SUSSEX COUNTY COUNCIL CONSULTATION

TO:	Arun District Council FAO: D <u>Johnson</u>
FROM:	WSSC - Highways Authority
DATE:	03 December 2019
LOCATION:	The Beach Hotel, former Mud Club & 2-4 Waterloo Square Bognor Regis <u>PO21 1SU</u>
SUBJECT:	BR/282/19 Redevelopment into 49 No apartments consisting of 24 No 1 & 25 No 2 bed apartments & 2 No commercial units (A3 Restaurant & Cafe). This application affects the character & appearance of The <u>Steyne</u> , Bognor Regis Conservation Area & may affect the setting of a listed building.
RECOMMENDATION:	More Information
S106 CONTRIBUTION TOTAL:	£ provided separately

Drawing Number / Revision:
18.103.201

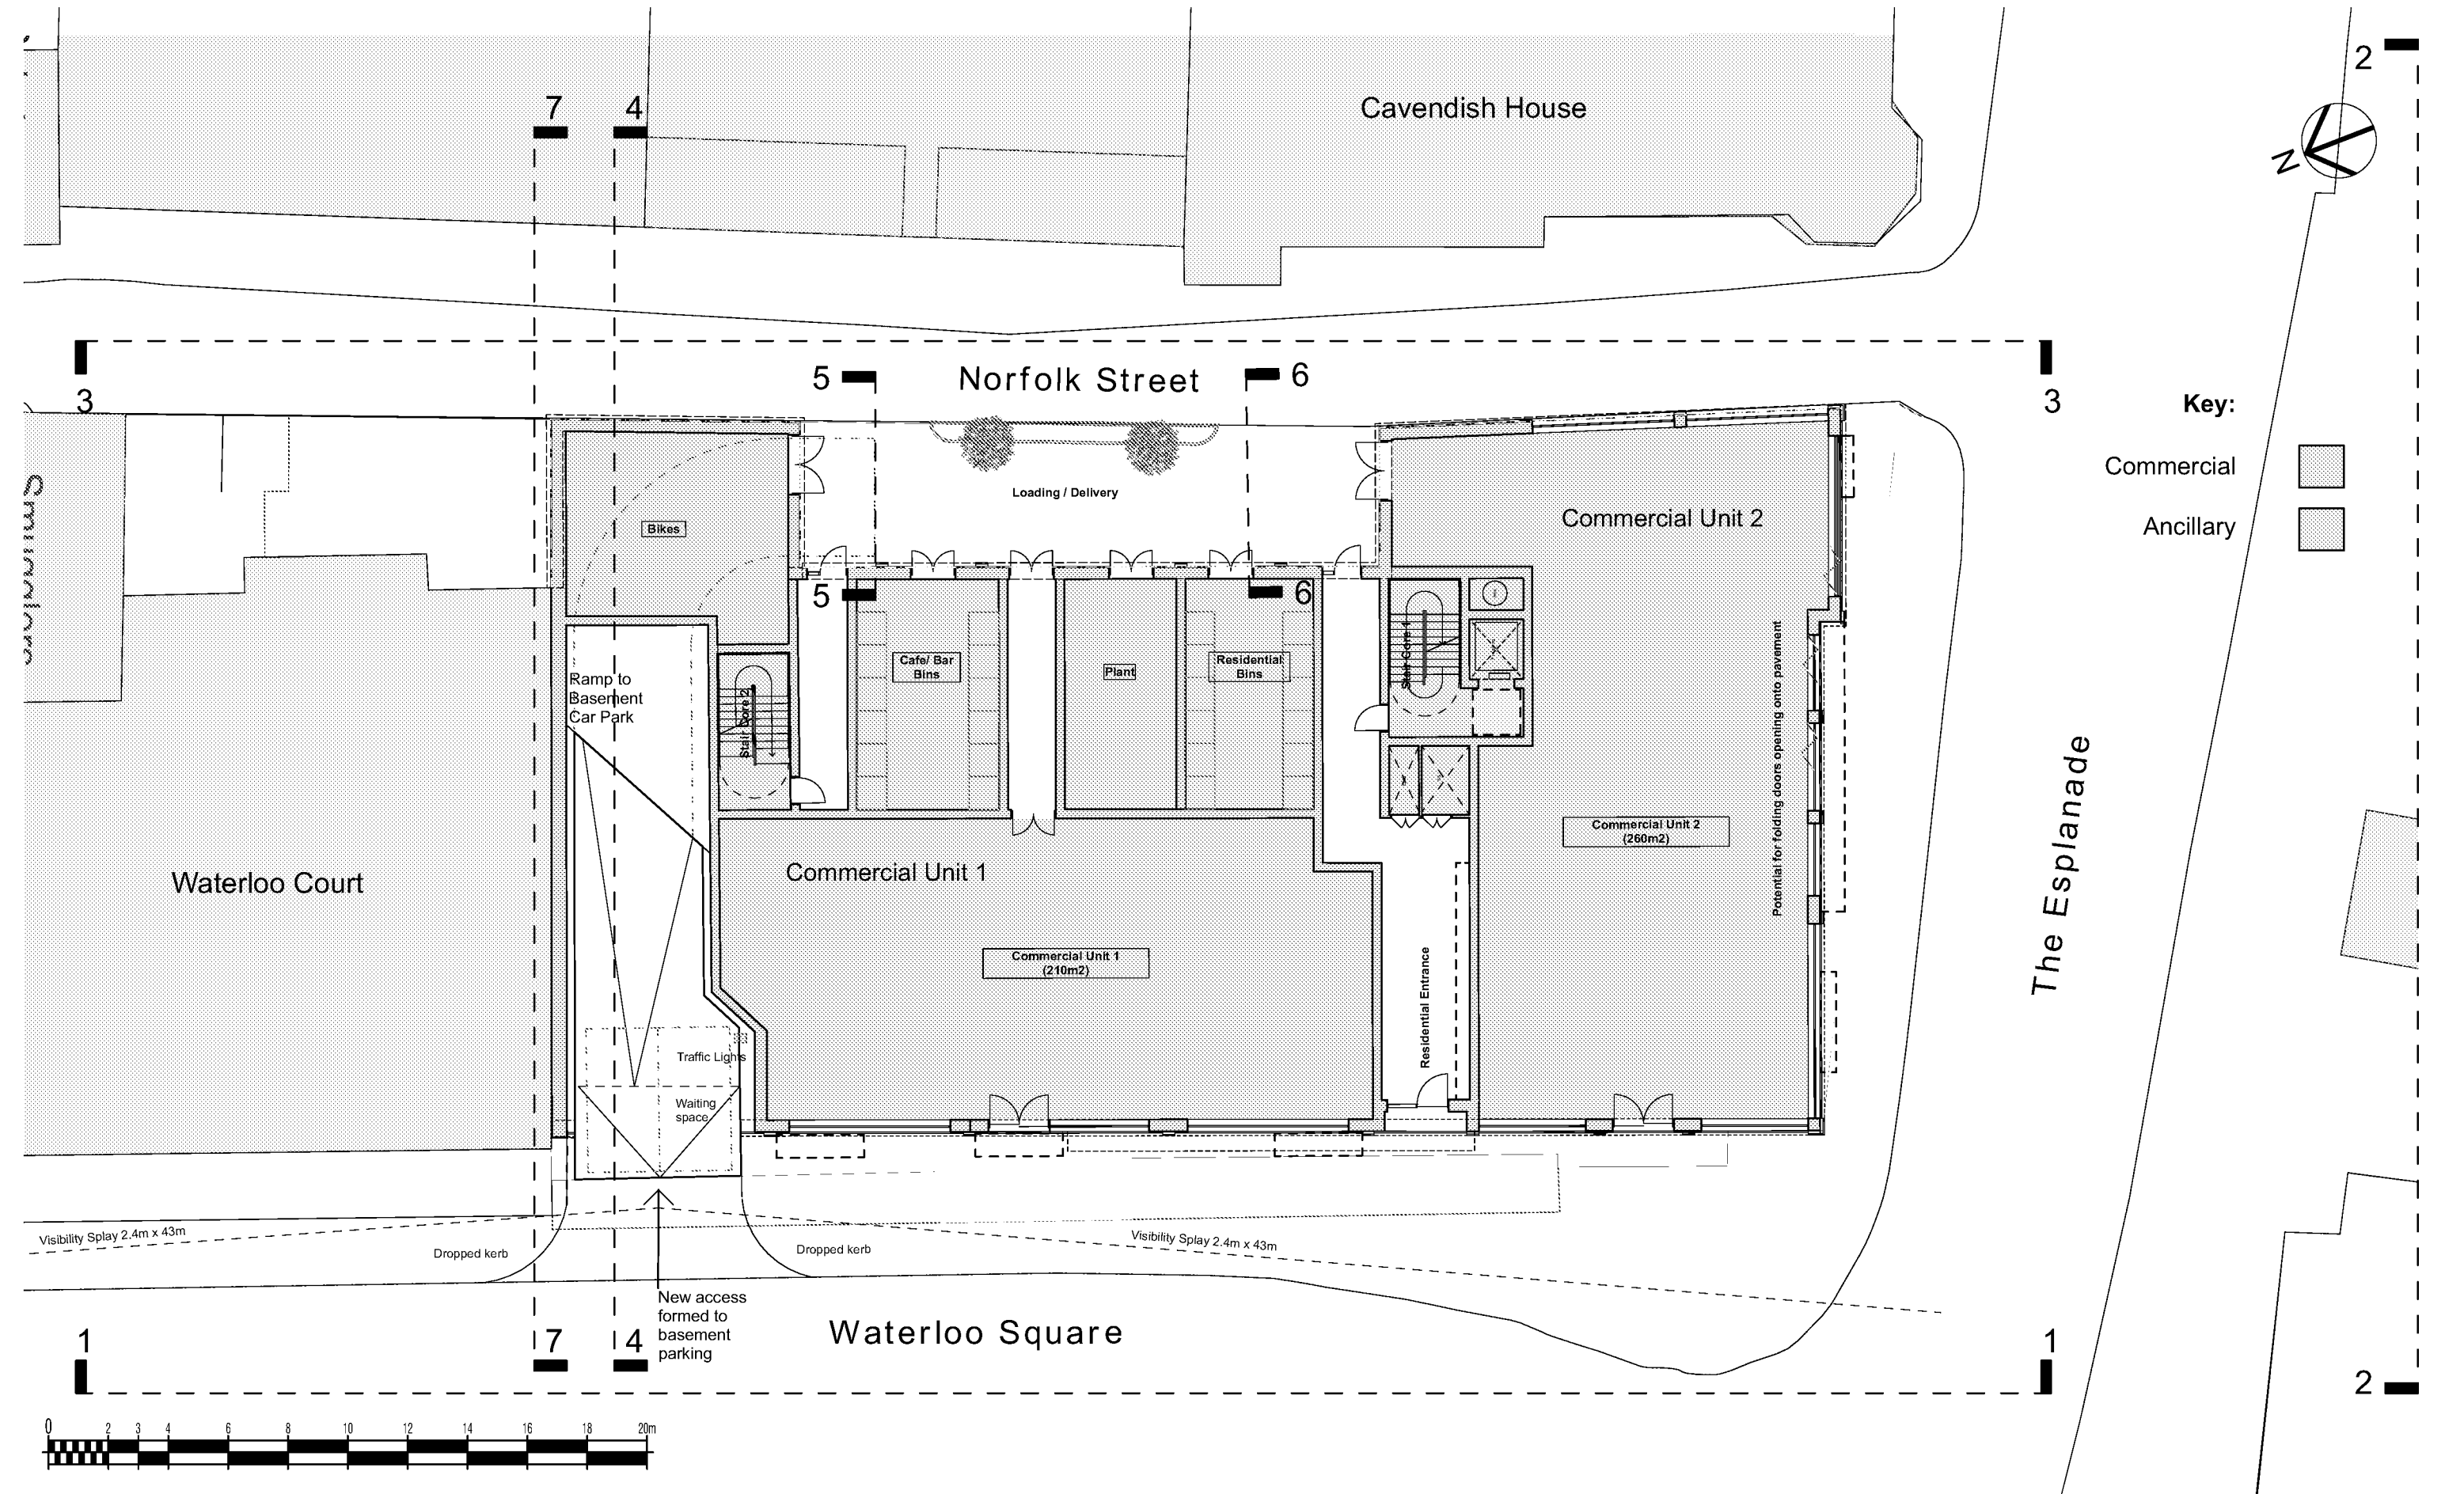
The layout of the basement car parking has been demonstrated with 2 x spaces being for disabled use. These bays should include an additional width of 1.2m on *each* side. If the bays were positioned side by side then the same 1.2m width of hatching for access could be used. The applicant should amend the parking layout accordingly.

Consideration should also be given to the proposed access widths within the basement level and ability for two cars to pass. Whilst it is appreciated that vehicle speeds will be low, the positioning of the motorcycle spaces and spaces 1-2 could result in conflict between cars travelling in opposing directions. The applicant should remove these spaces and provide full swept path tracking plans to demonstrate the layout is operational, including use of internally marked 'waiting space'. The applicant should also consider providing some electric vehicle charging points. As per access comments the applicant should also clarify how traffic light system will work.

- Demonstrate full workability of parking layout including removal of spaces 1-2 and motorcycle parking and amended disabled parking bays. Also clarify whether electric vehicle charging points will be provided.

Access Overview and Visibility Splays

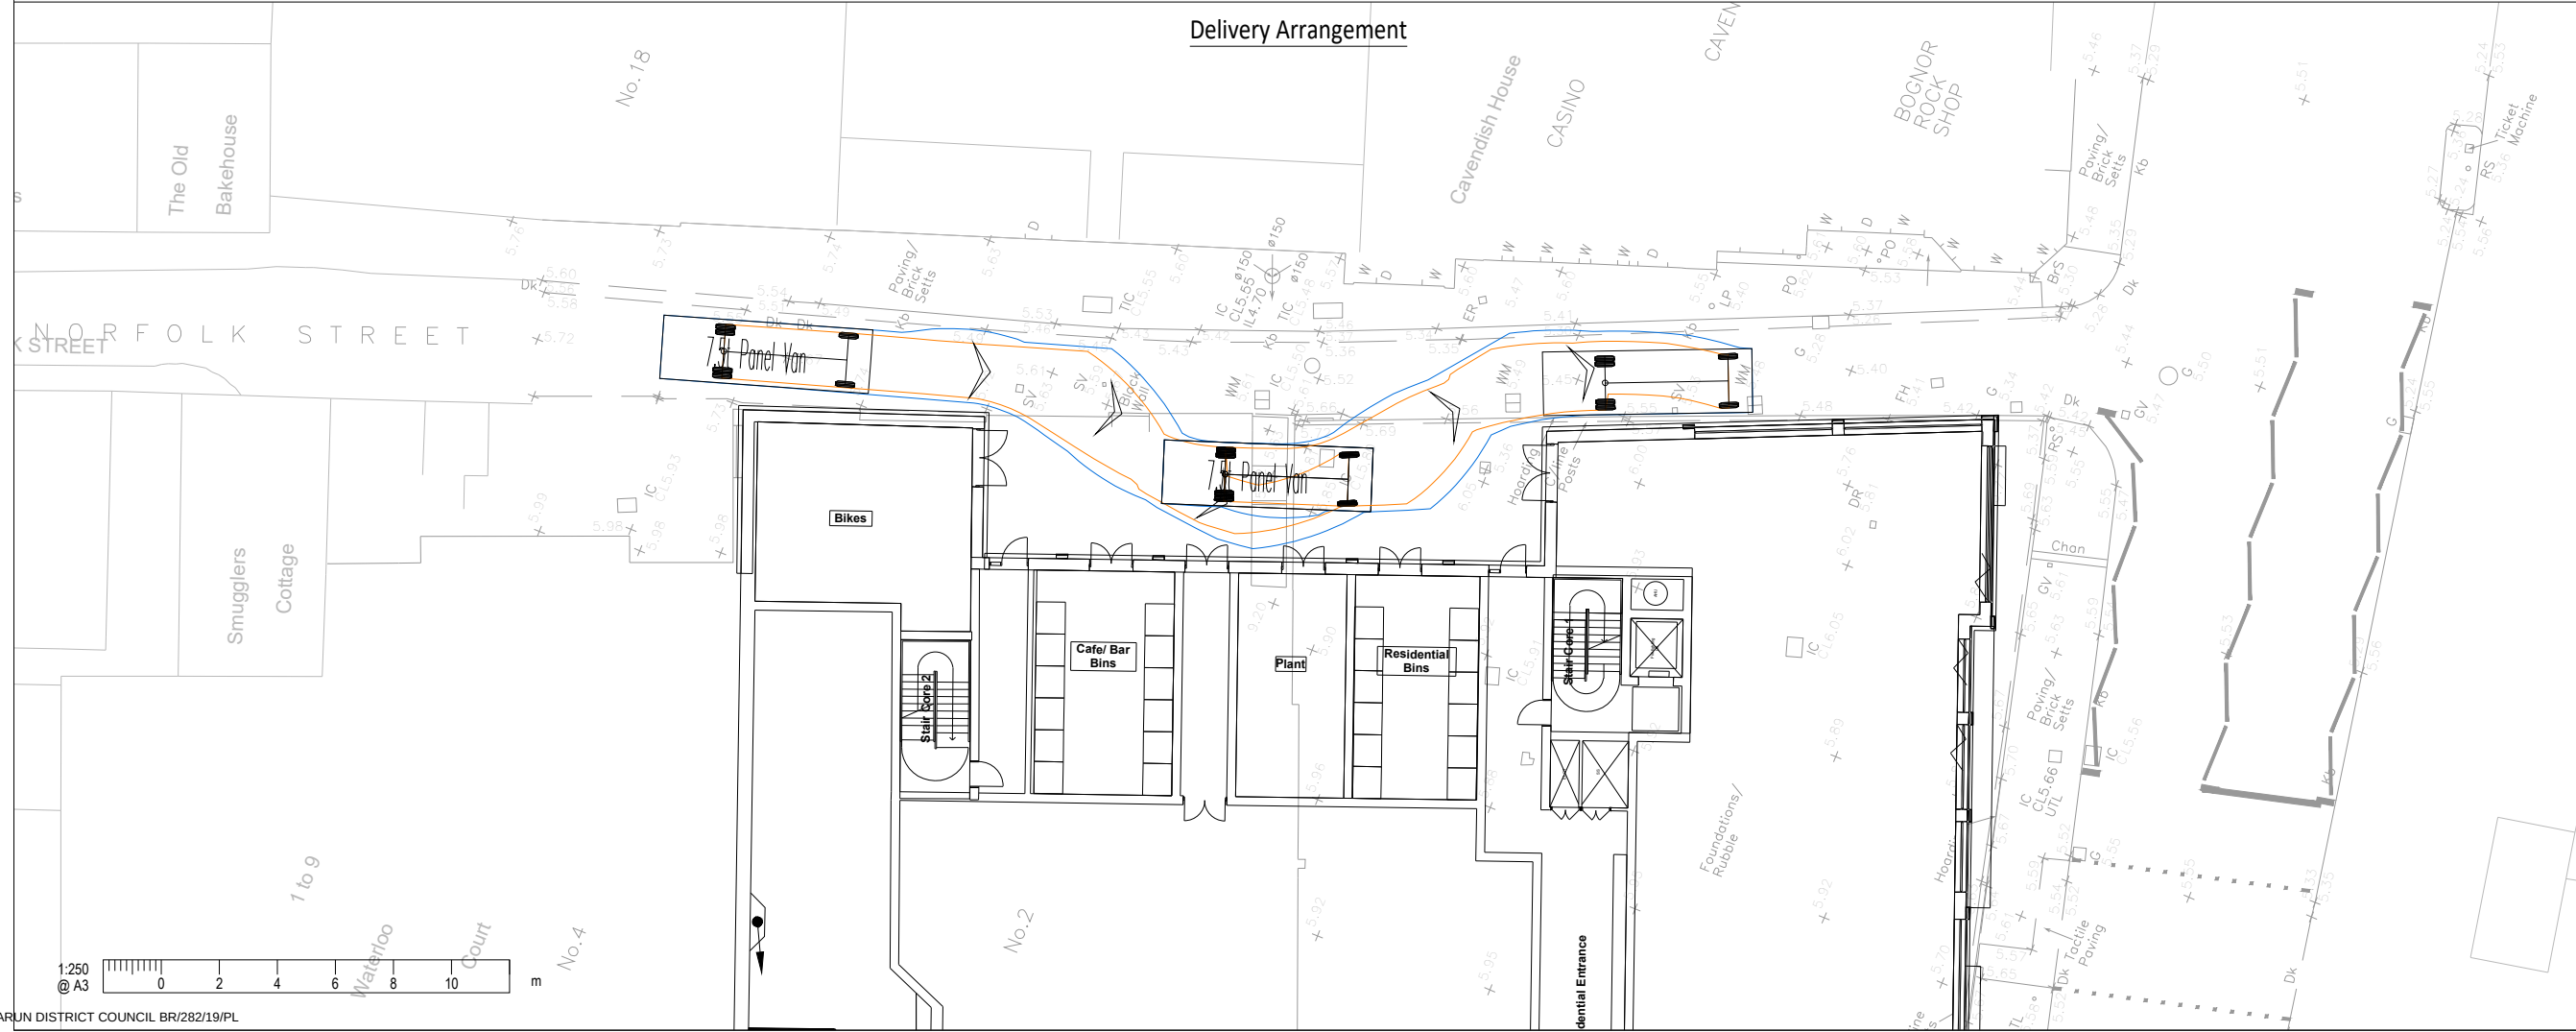
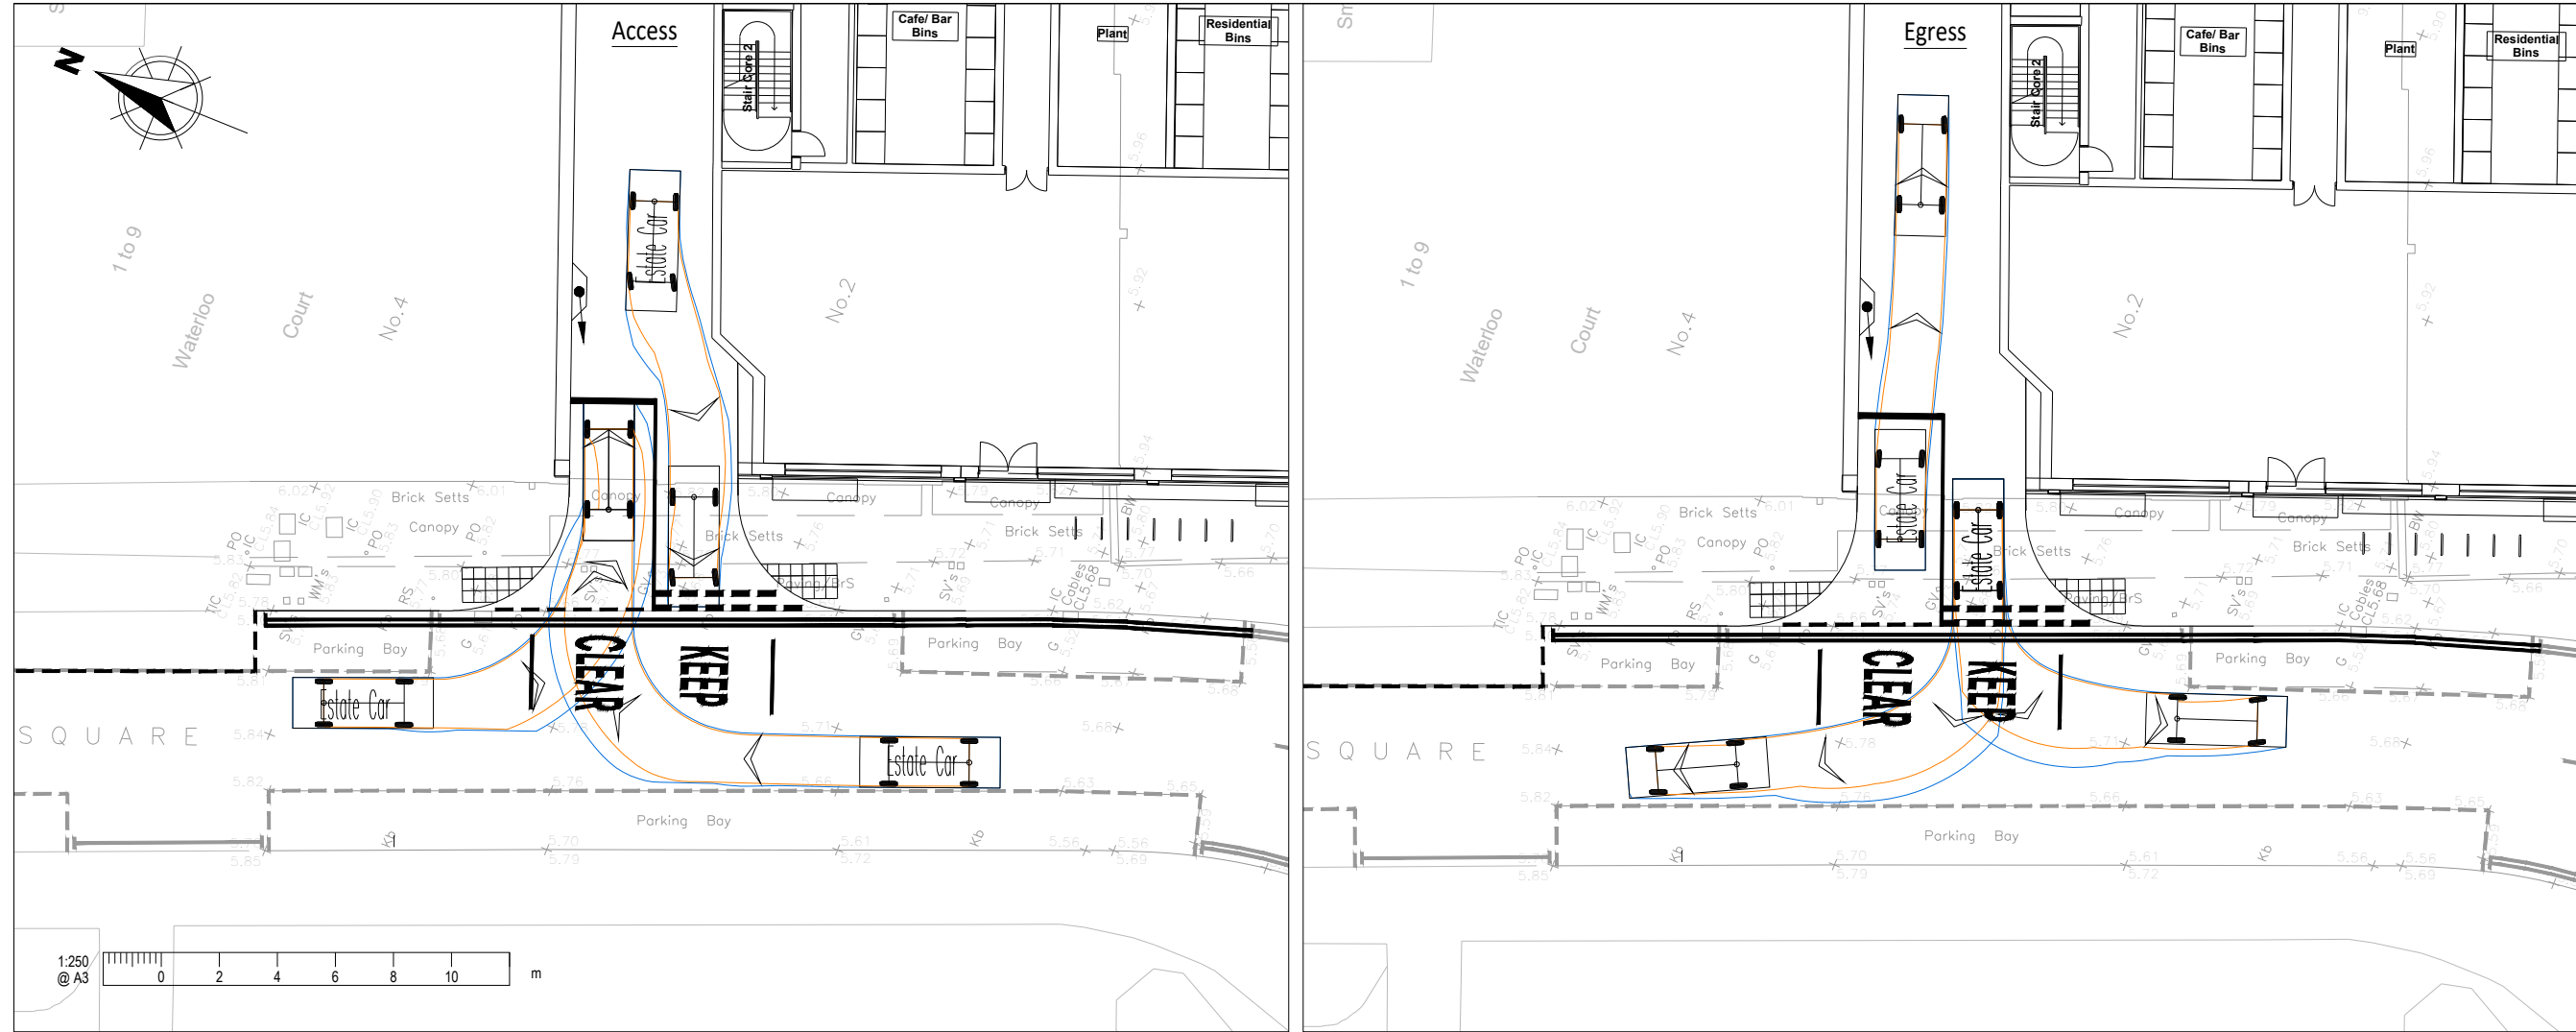
A new vehicular access from Waterloo Square is proposed to serve the basement level car park. An inspection of local mapping shows the kerb is dropped in this location and double yellow lines present so no impact to existing controlled on-street parking areas is anticipated. The access should be kerbed with radii and tactile paving across this to aid pedestrian movement on the existing footway. Some of the existing dropped kerb will need to be removed and the kerb line reinstated. The works will require a minor works licence and technical approval however the applicant should first provide a Stage One Road Safety Audit (RSA) on the proposed access works/ alterations to public highway.

Vehicular visibility splays of 2.4m by 43m have been demonstrated from the site access on to Waterloo Square. This is in accordance with Manual for Streets (MfS) guidance for vehicle speeds of 30mph. The splays are achievable within the private access and publicly maintained highway and extend past the junction with The Esplanade to the south. The full extent of the splay to the north has not been shown. From an inspection of WSCC mapping this does appear achievable, however the applicant should show the full extent of the splays. Due to the presence of adjacent building, wide pedestrian visibility splays to the adjacent footway are not achievable. Nevertheless, paragraph 10.6.1 of MfS 2 states that vehicle exits at the back edge of the footway mean that emerging drivers will have to take account of people on the footway. The absence of wide visibility splays at minor accesses will encourage drivers to emerge more cautiously - similarly to how vehicles pull out when visibility along the carriageway is restricted. Considering the proximity to junction and on-street parking it is anticipated that vehicle speeds would not be exceeding the posted limit and that due to similar neighbouring accesses, drivers and pedestrians would react to the environment accordingly.

- Clarify proposed access alterations including demonstration of extent of dropped kerb to be reinstated and proposed kerbed radii and tactile paving works. Also provide full extent of vehicular visibility splays.
